The Planning Inspectorate
National Infrastructure Directorate
Temple Quay House
Temple Quay
Bristol
BS1 6PN

Our ref: AE/2018/123154/01
Your ref: EN010079

Date: 07 September 2018

RELEVANT REPRESENTATIONS – NORFOLK VANGUARD OFFSHORE WIND FARM. NOTICE OF ACCEPTANCE OF AN APPLICATION FOR A DEVELOPMENT CONSENT ORDER. SECTION 56 OF THE PLANNING ACT 2008, REGULATION 8 OF THE INFRASTRUCTURE PLANNING (APPLICATIONS: PRESCRIBED FORMS AND PROCEDURE) REGULATIONS 2009 AND REGULATION 13 OF THE INFRASTRUCTURE PLANNING (ENVIRONMENTAL IMPACT ASSESSMENT) REGULATIONS 2009

Sheet 16 of 27

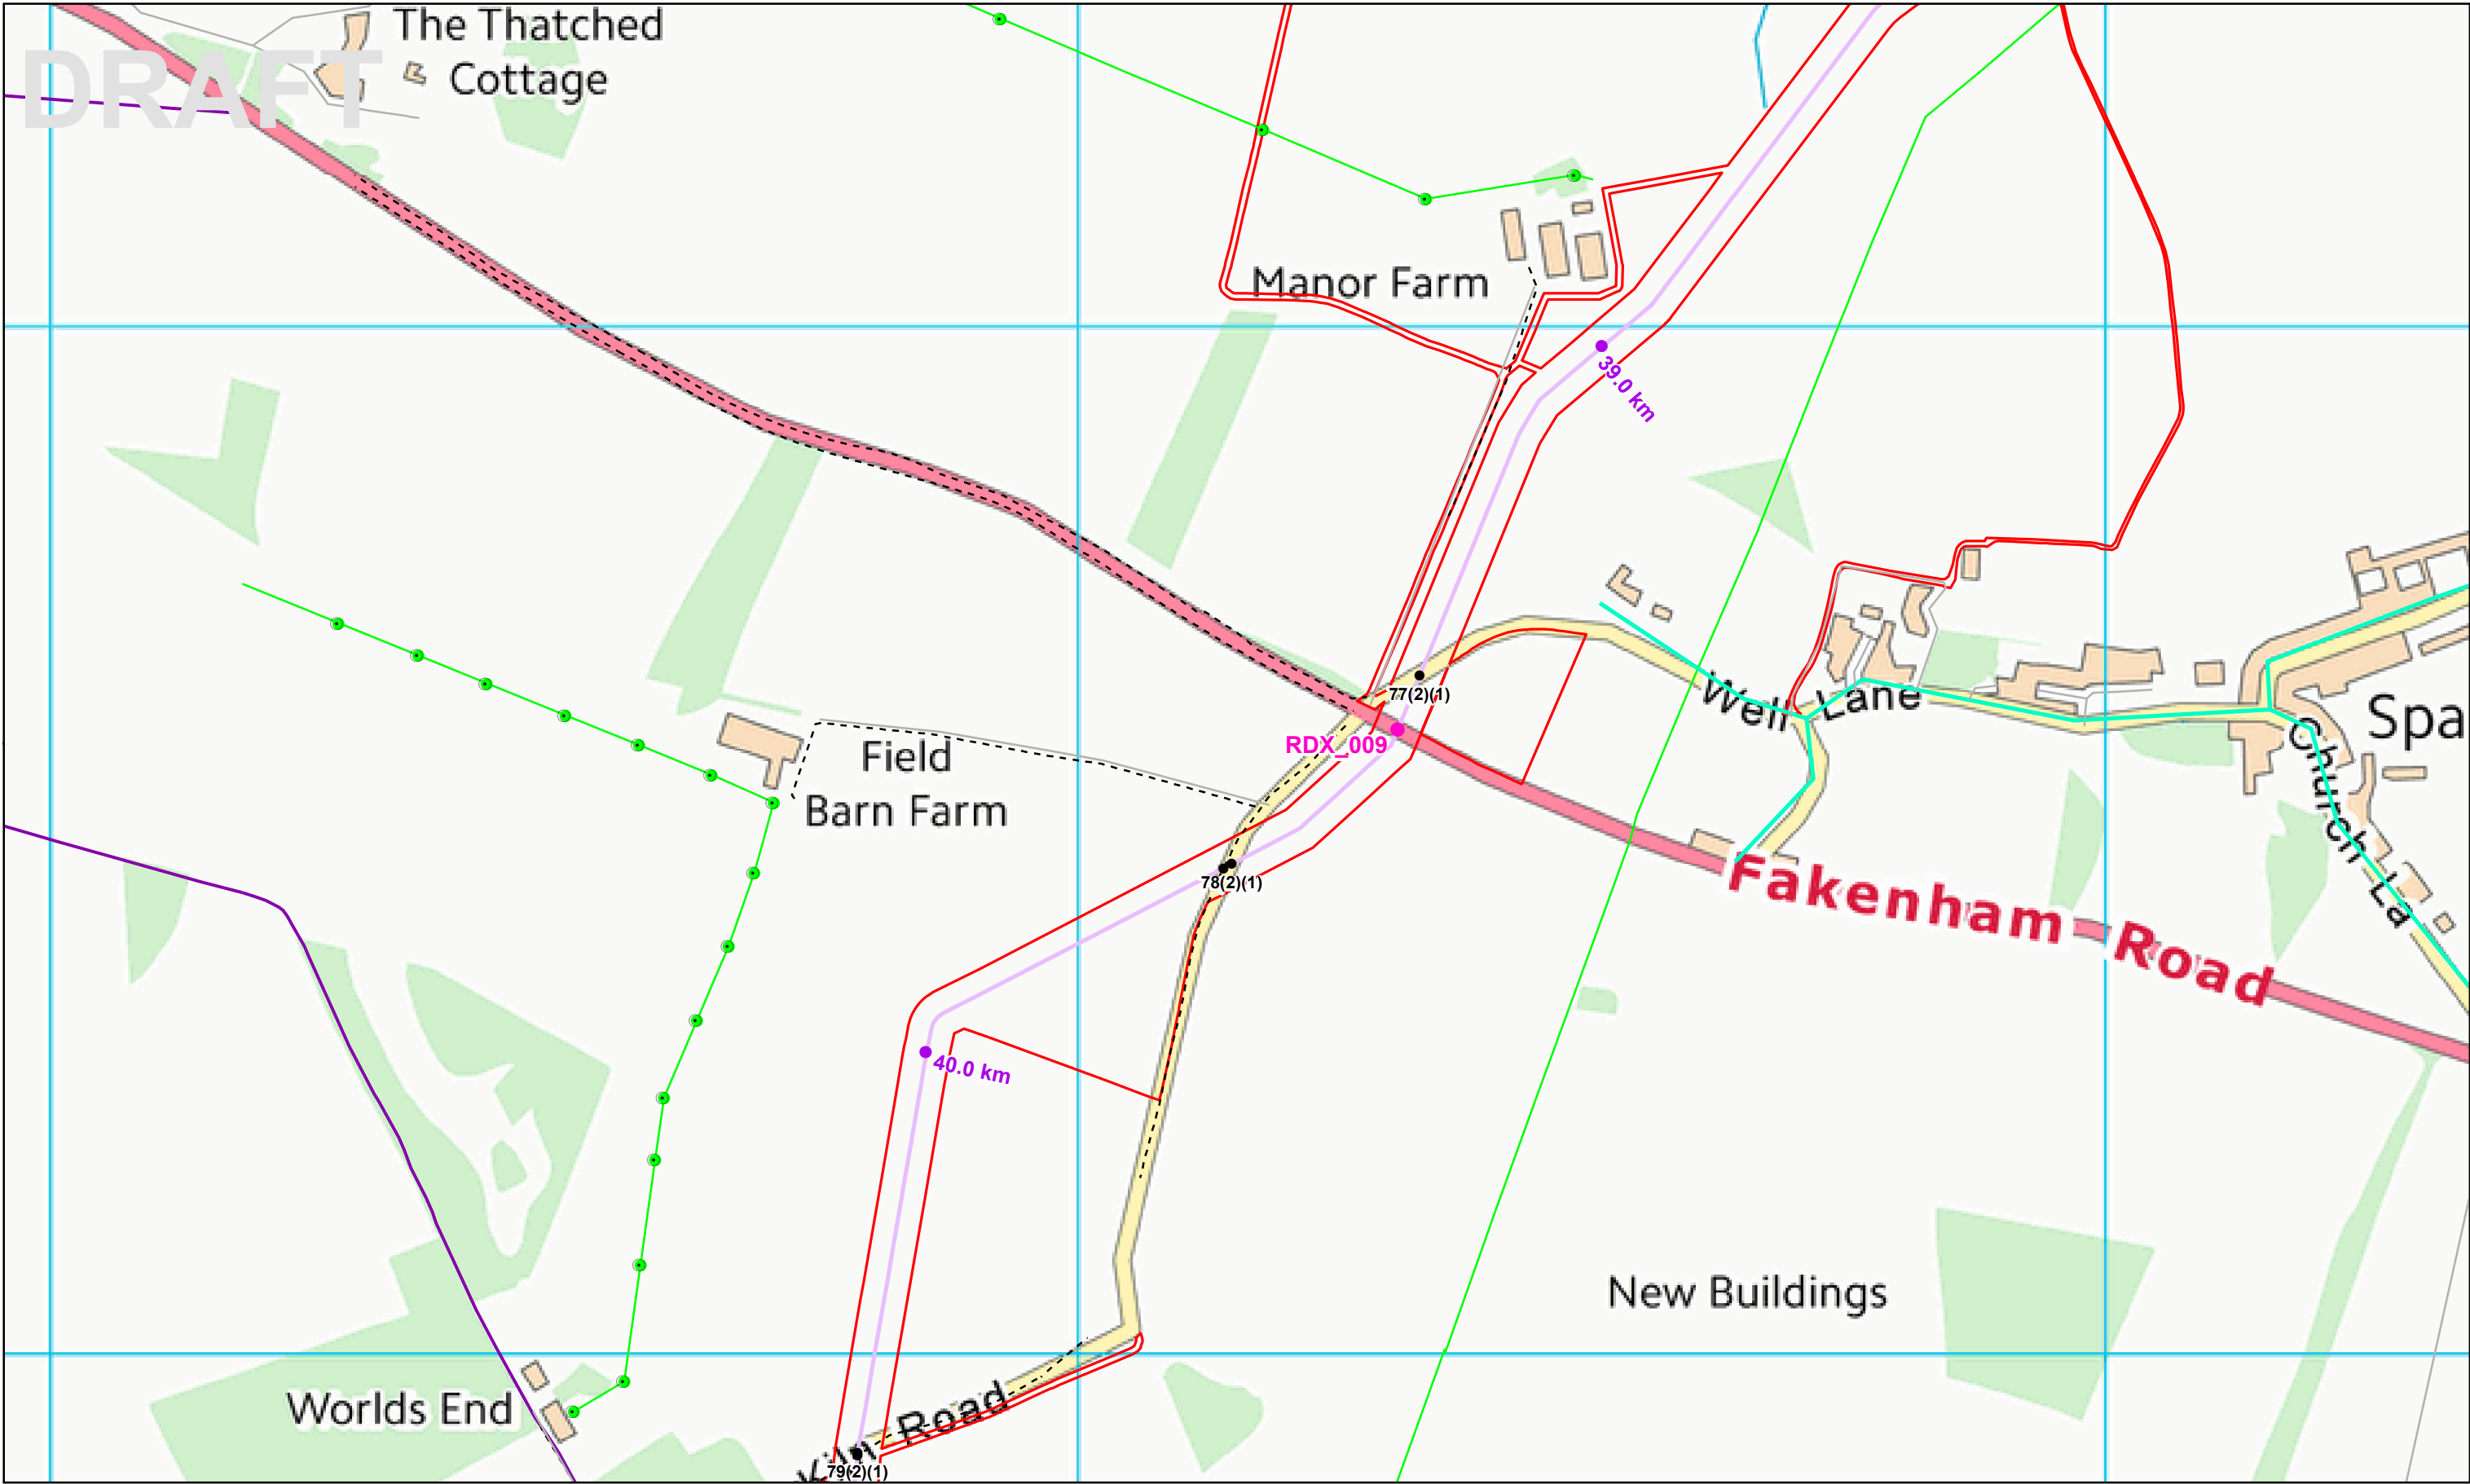
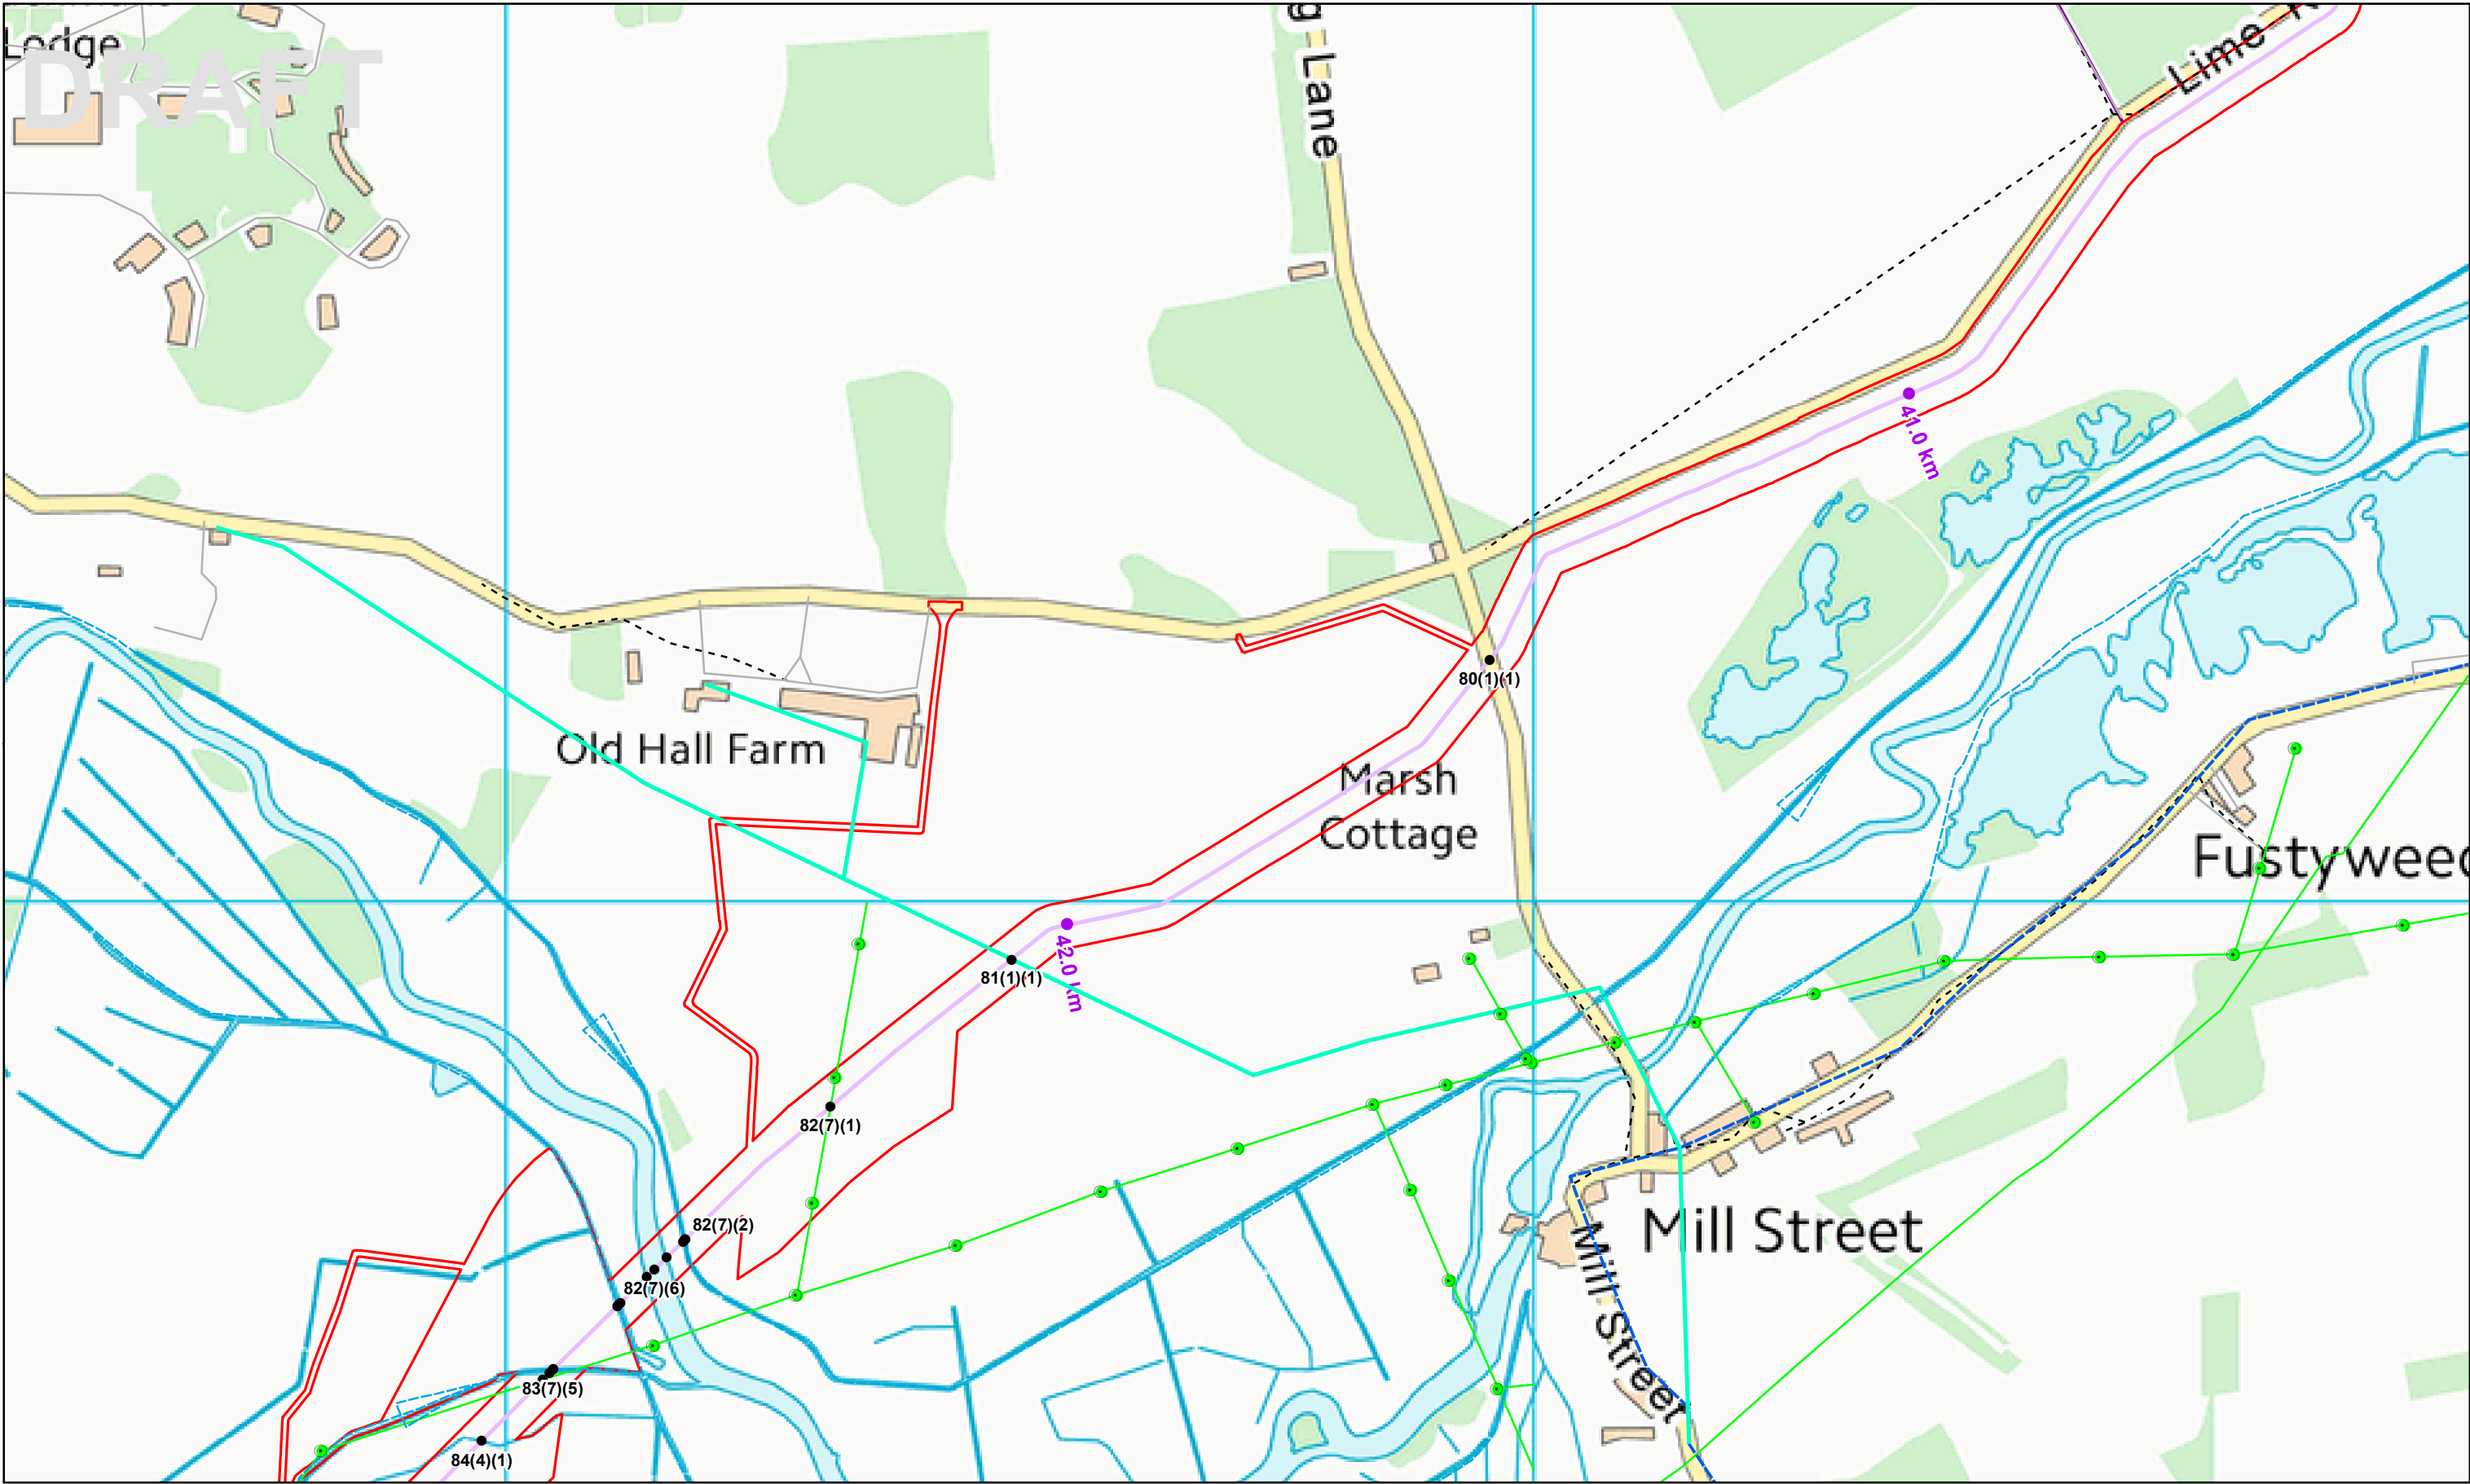
- 4.1 Table 20.1, Appendix 2.4 Detailed Watercourse Crossing Schedule, volume 3, sheet 16. The table shows that the Whitewater River is to be crossed by using open trench techniques.

- 4.2 The Whitewater River is a main river and the applicant will require an environmental permit unless the legislation relating to environmental permits is disapplied. For either of these options it will be necessary for the applicant to demonstrate that flood risk to the surrounding area will not be increased as a result of the works.
